Tuesday 14th May 2019

**Application by SP Manweb for an Order Granting Development Consent for the Reinforcement to the North Shropshire Electricity Distribution Network**

**Canal & River Trust Response submission for deadline three**

### **Montgomery Canal Crossing**

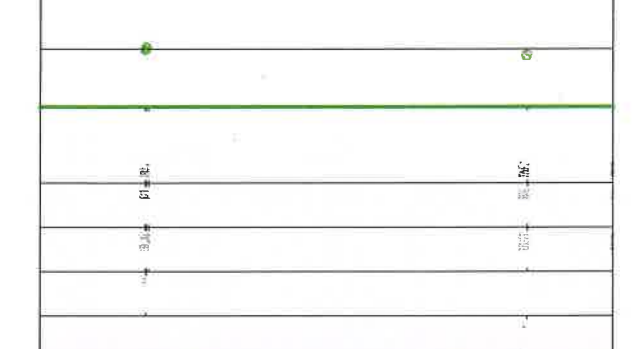
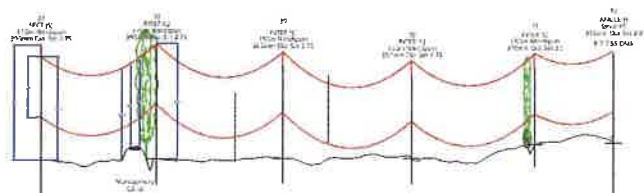
The Trust raised concerns in its relevant representation in relation to the height of poles 37 and 38 and the resultant clearance over the canal. The applicant provided details and a cross section showing the clearance on 27<sup>th</sup> March. Having now reviewed these details the Trust is satisfied that there would be sufficient clearance over the canal.
